# Charlotte Department of Transportation

## Memorandum

**Subject:** Rezoning Petition 04-095: The East side of Providence Road between  
Mammoth Oaks Drive and Shelton Street  
(Revised 6/18/07)

SITE PLAN

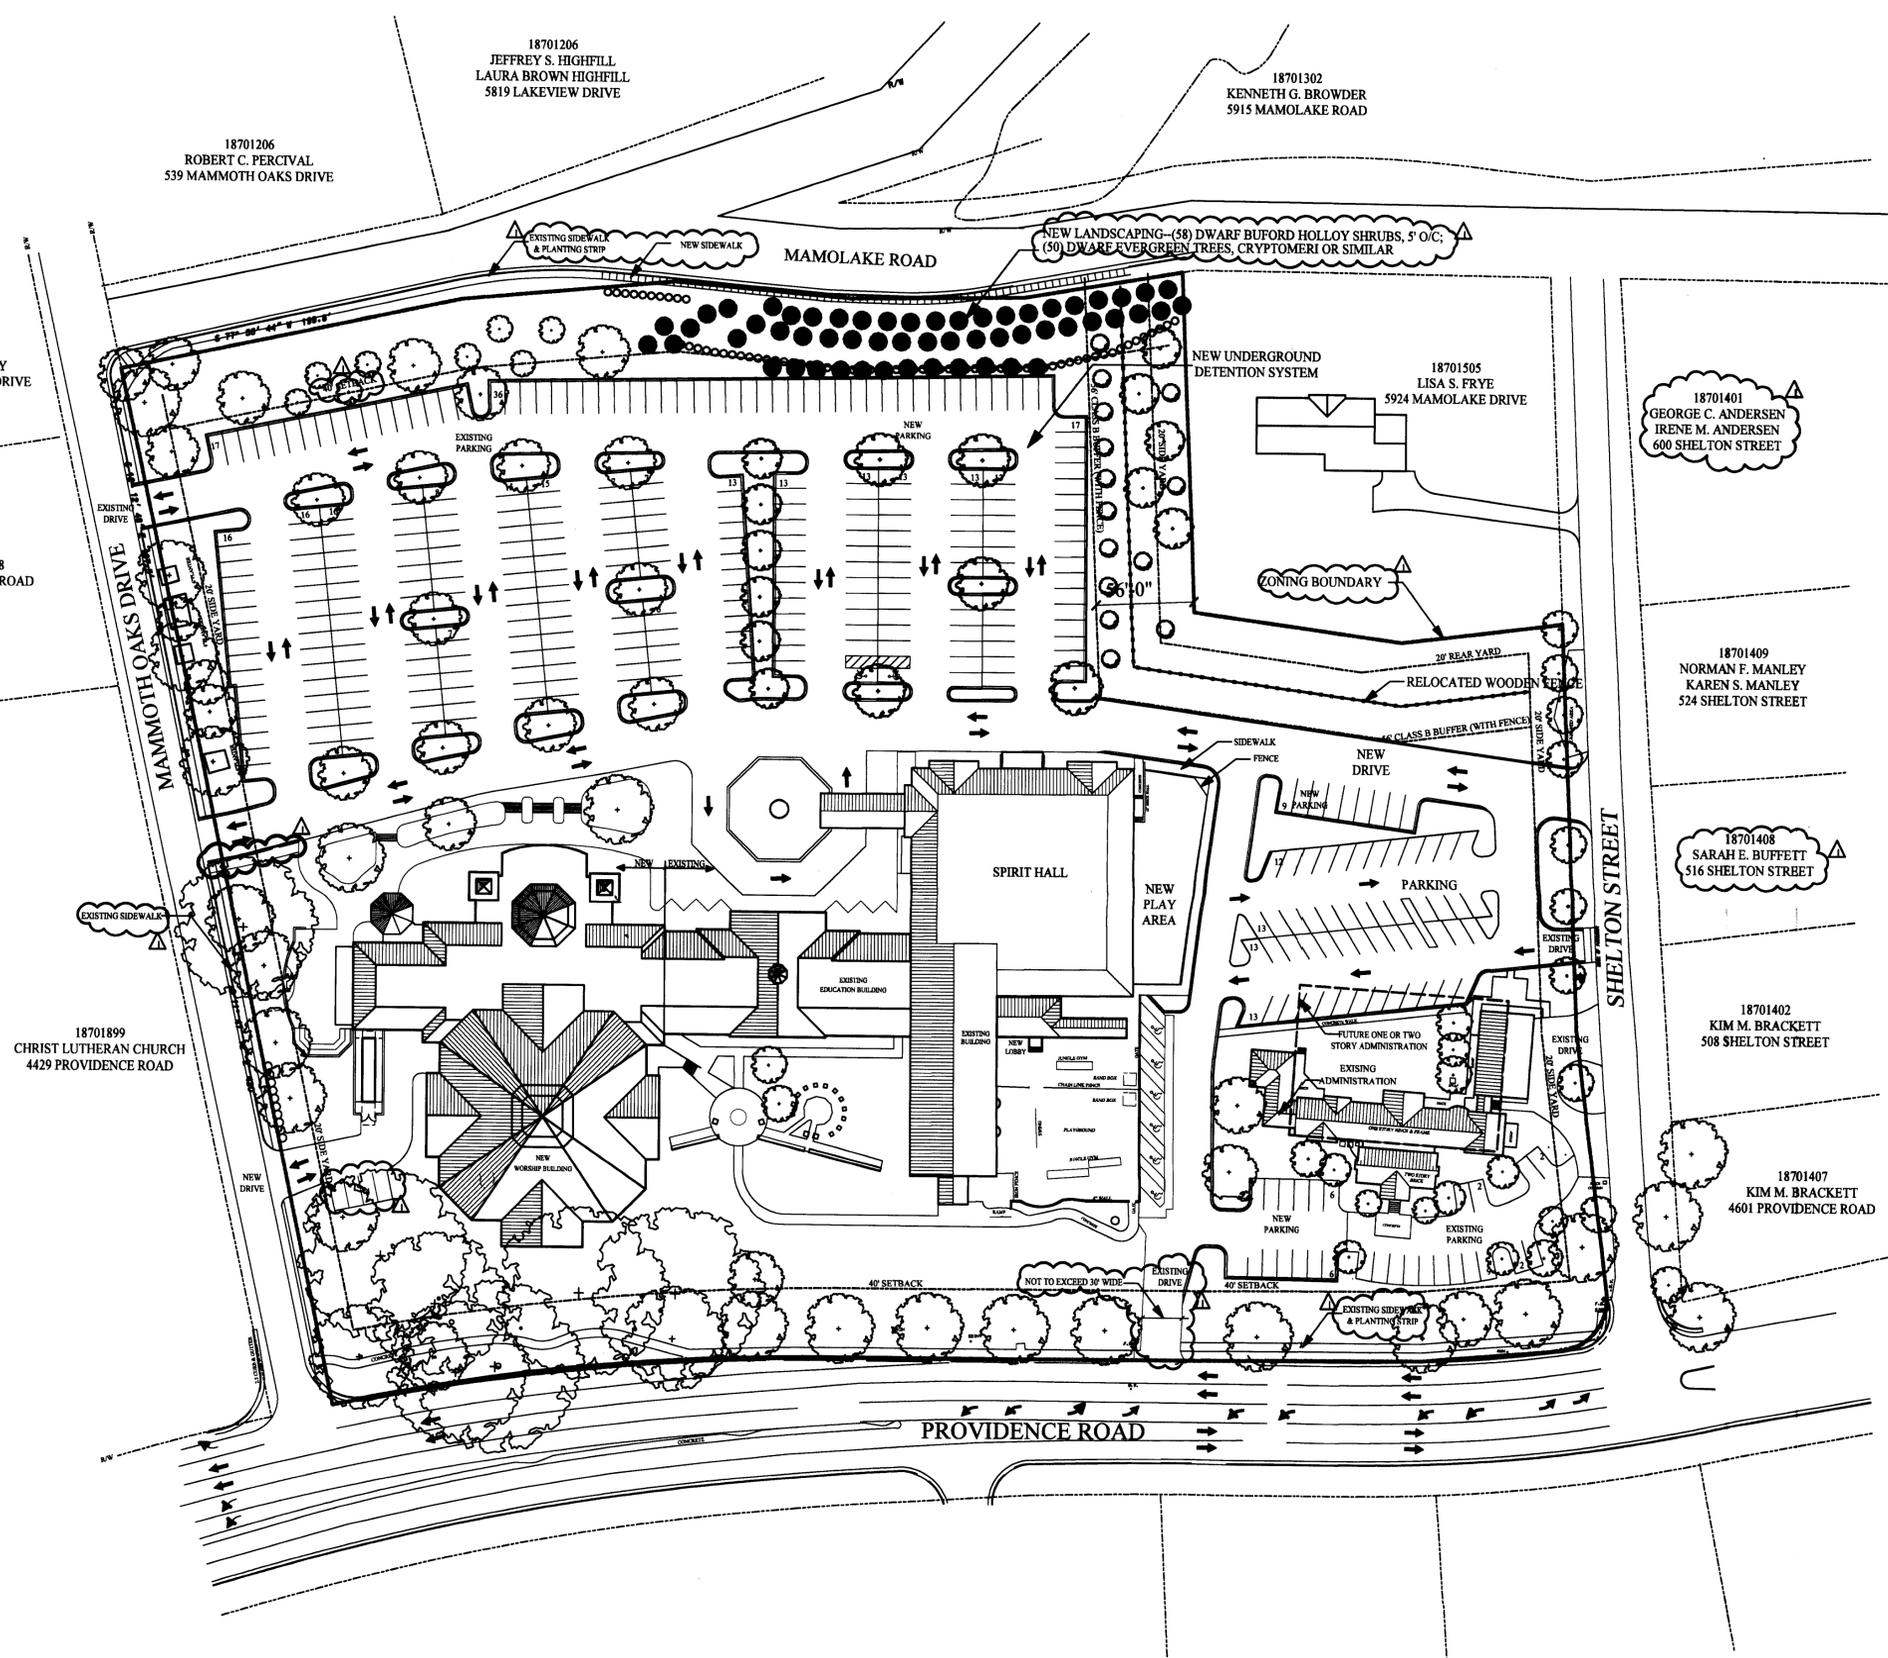
1. The existing one-way driveway connection to Providence Road should be shown having a maximum width of 30 feet and perpendicular to street. As shown the driveway is too wide and will not be approved. The parking lot drive aisle that is proposed to connect to this driveway should be marked to prevent vehicles from turning left toward Providence Road. *(Previous Review Comment)*
